Planning Application Reference No.: 3/2026/0354

Address of Development: 13 Brookside
Old Langho
BB6 8AP

Comments: Subject: Objections to Proposed Extension

Client	Liam Wilson		
Project	13 Brookside, Old Langho 2 Storey Side Extension		
Drawing	Scheme 1 - plans & elevations		
Date	Drawn by	Scales	
April 2026	MJ	1:50	@ A1
Job No - Dwg No - Rev	HA26008 - SK1 - C

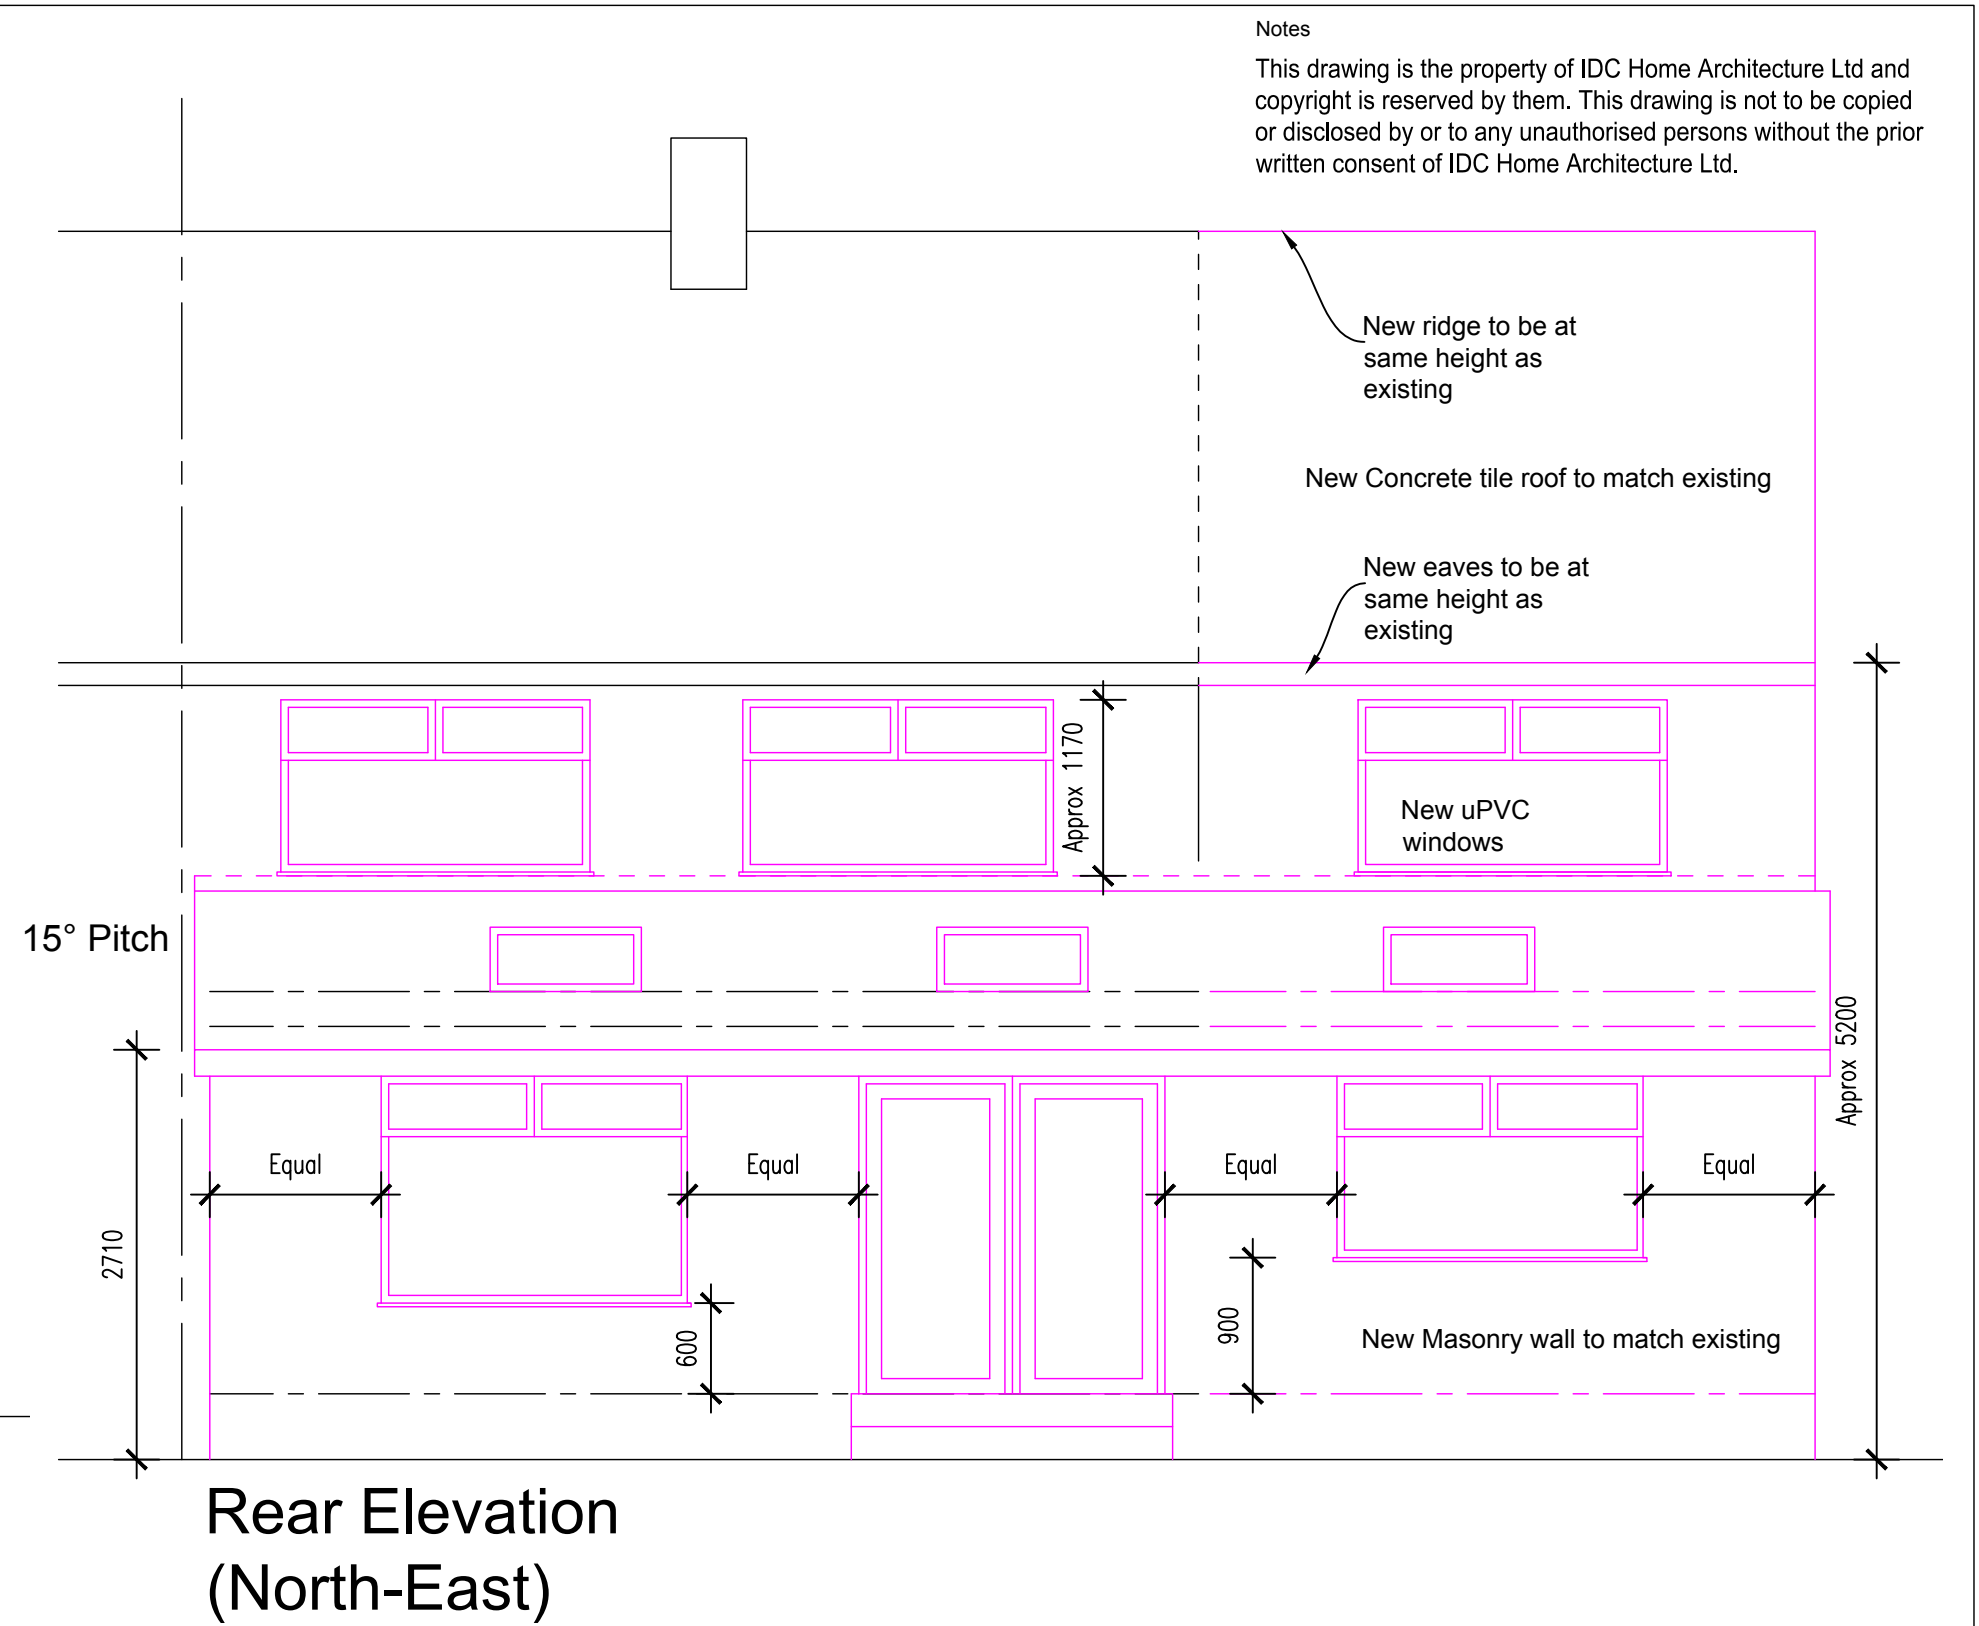
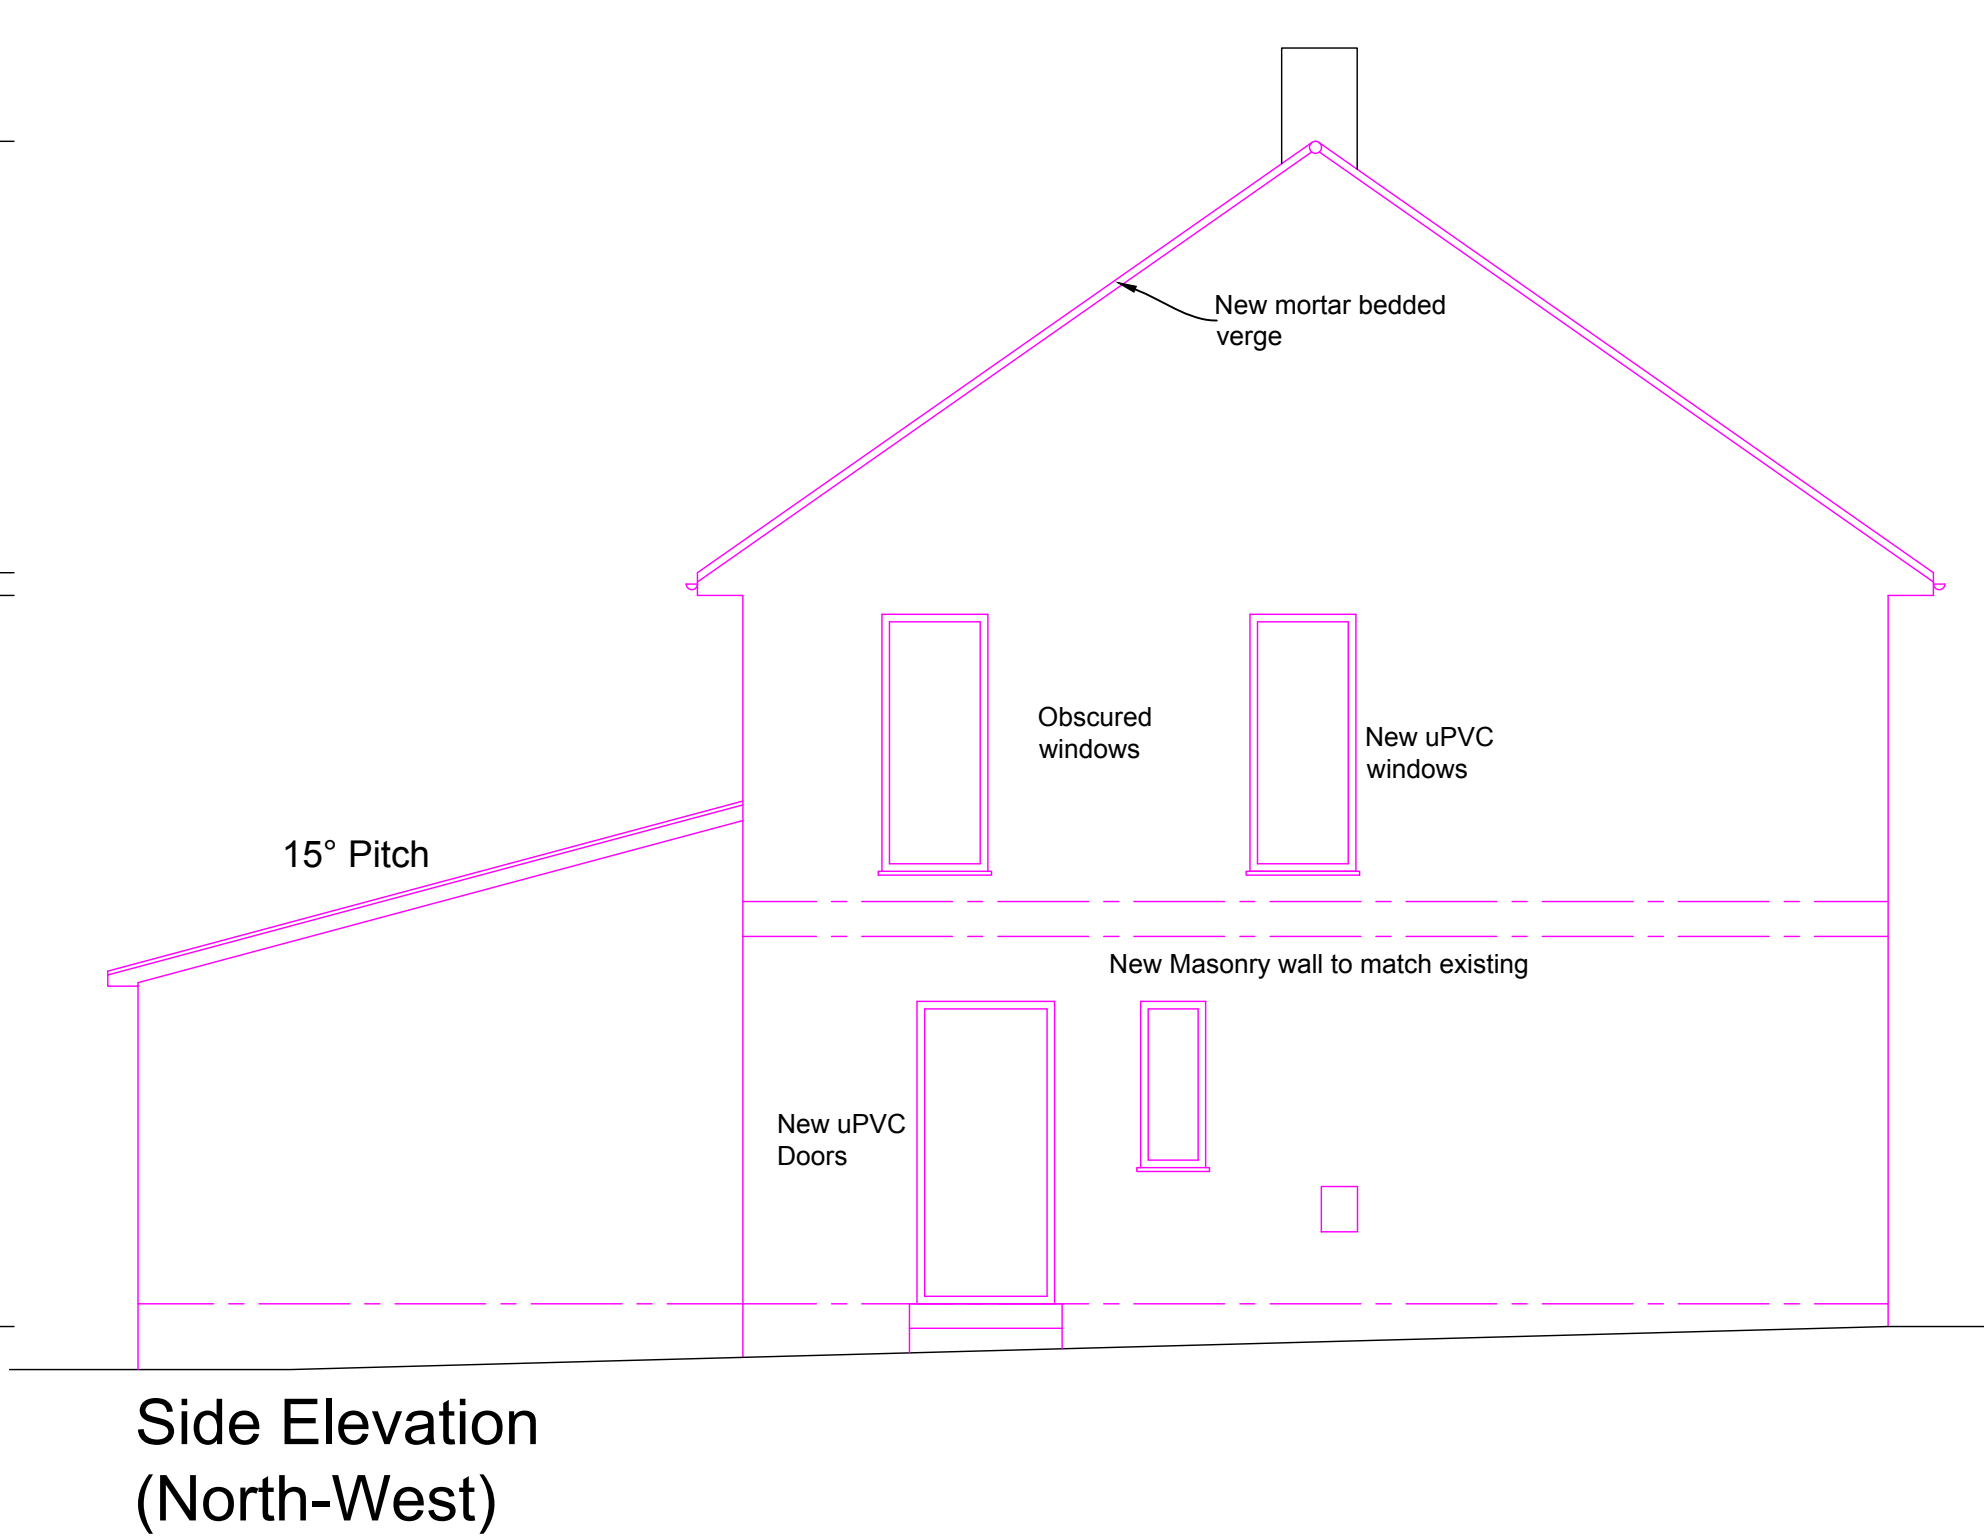
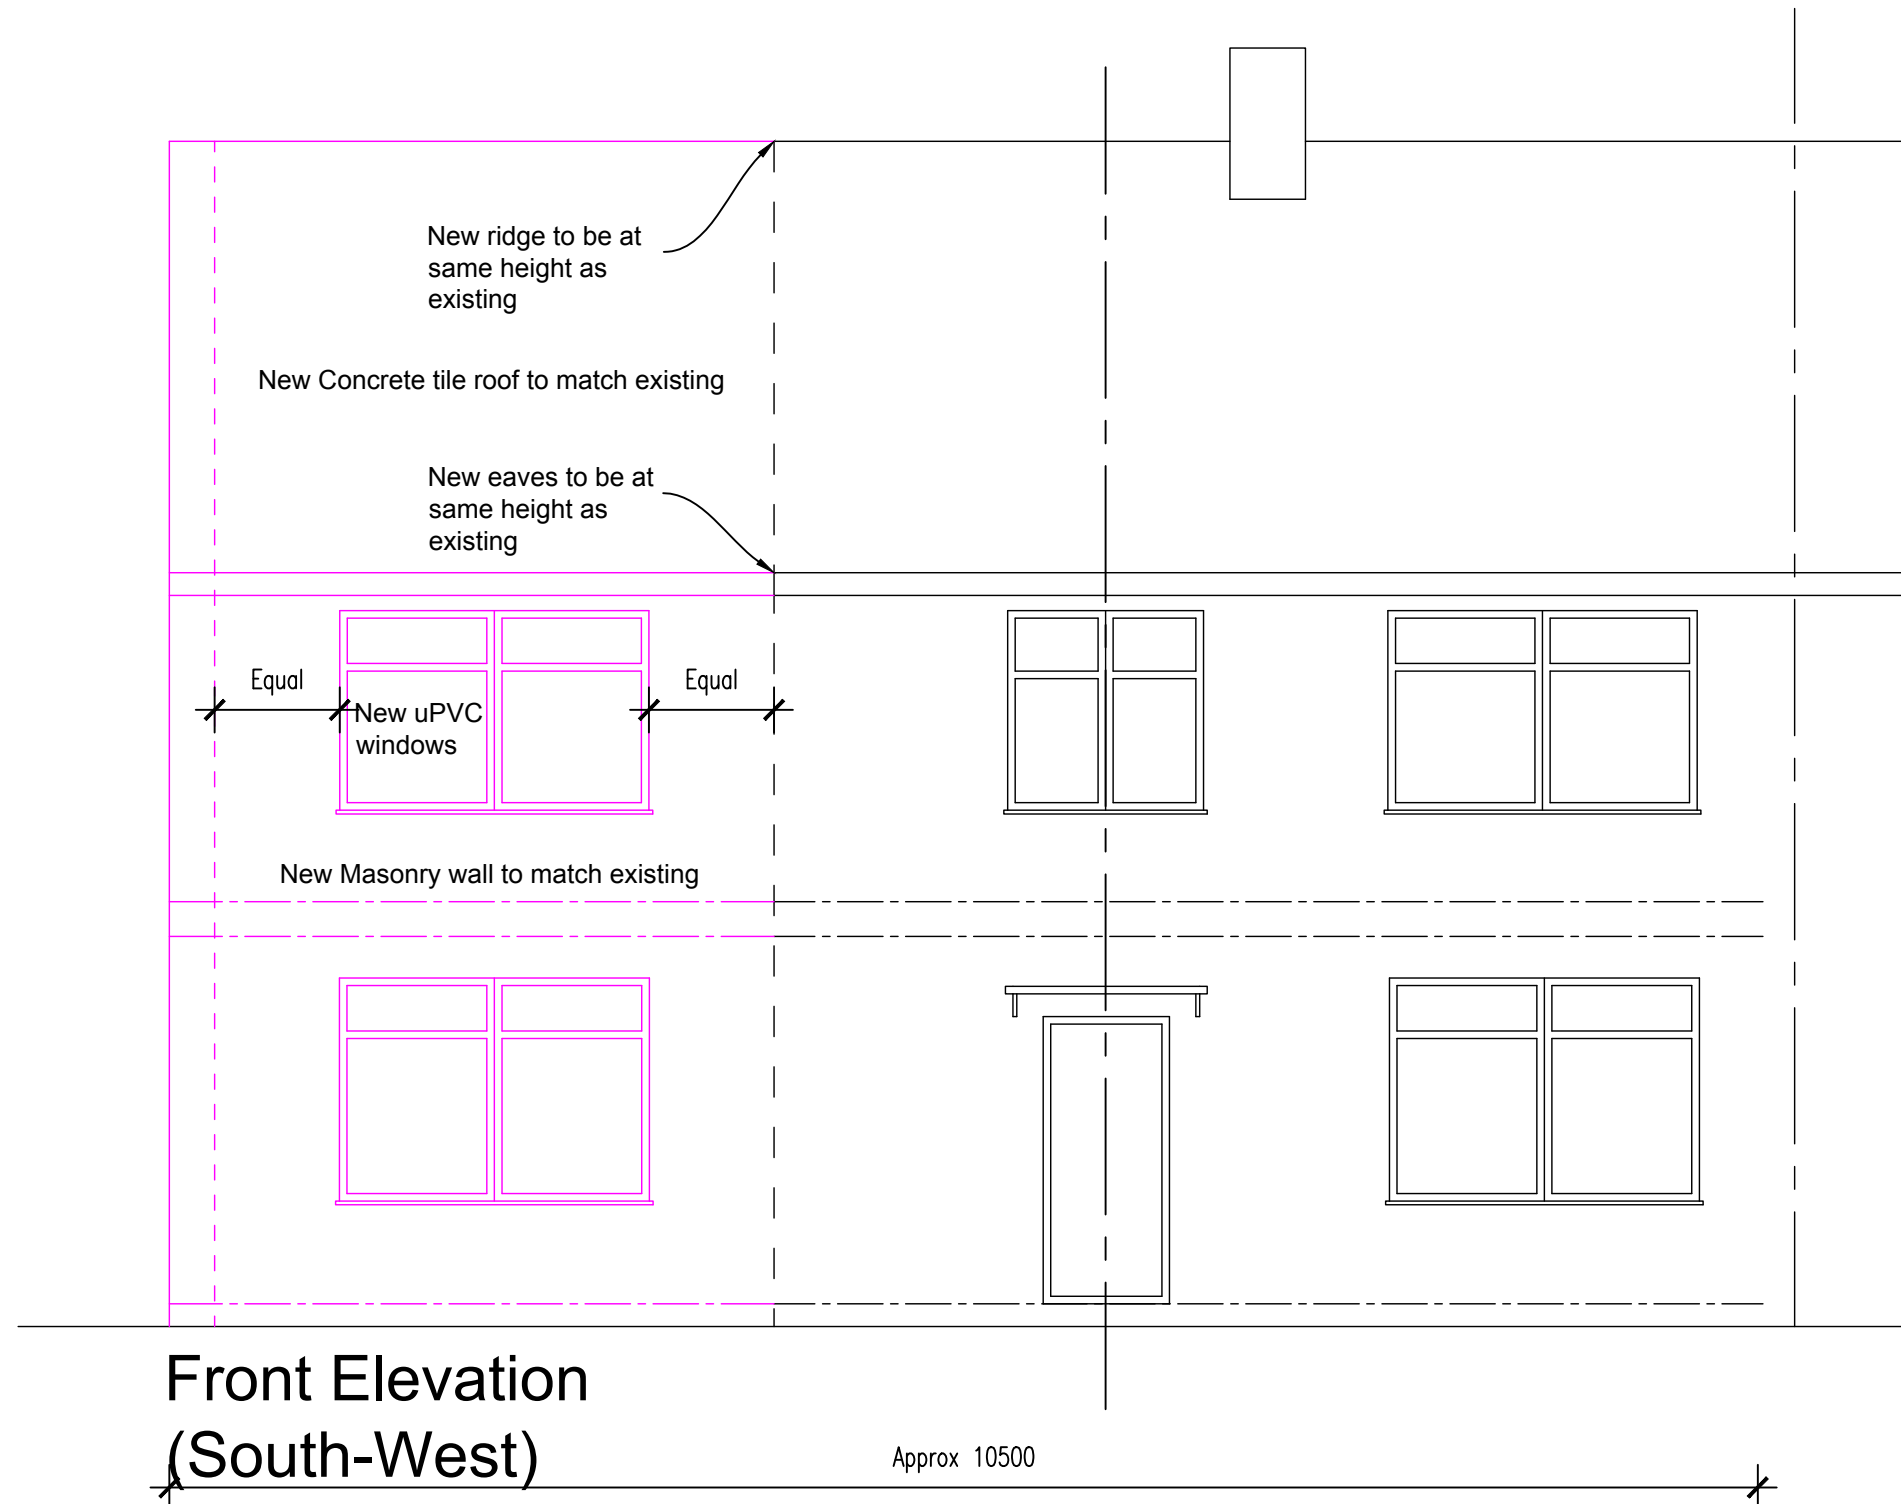
While I appreciate that homeowners are entitled to improve their property, I have concerns regarding both the scale of the proposed development and the impact it will have on neighbouring homes. I am particularly concerned about the proposed first-floor front en-suite window, which would [REDACTED] Given the relatively narrow distance between the houses, this window would result in a significant loss of privacy and allow [REDACTED] The sheer size of a clear glass window as a en-suite in this location would cause a direct and highly intrusive invasion of privacy into [REDACTED] I believe this would be contrary to Ribble Valley Core Strategy Policy DMG1, which seeks to protect the residential amenity of existing neighbouring properties.

As this window serves a non-habitable bathroom rather than a primary living space or bedroom, I do not believe clear glazing is necessary. I therefore respectfully request that, should planning permission be granted, the Local Planning Authority imposes a condition requiring the en-suite window to be in keeping with a normal size bathroom window and fitted with obscure glazing (minimum Pilkington Privacy Level 3 or 4) and to be non-opening below 1.7 metres above the internal floor level, in order to protect the privacy of neighbouring residents.

I have also concerned that the overall size and scale of the extension is excessive for the plot and will have a detrimental impact on the character of the surrounding area. This development appears much larger than neighbouring properties and risks being overbearing.
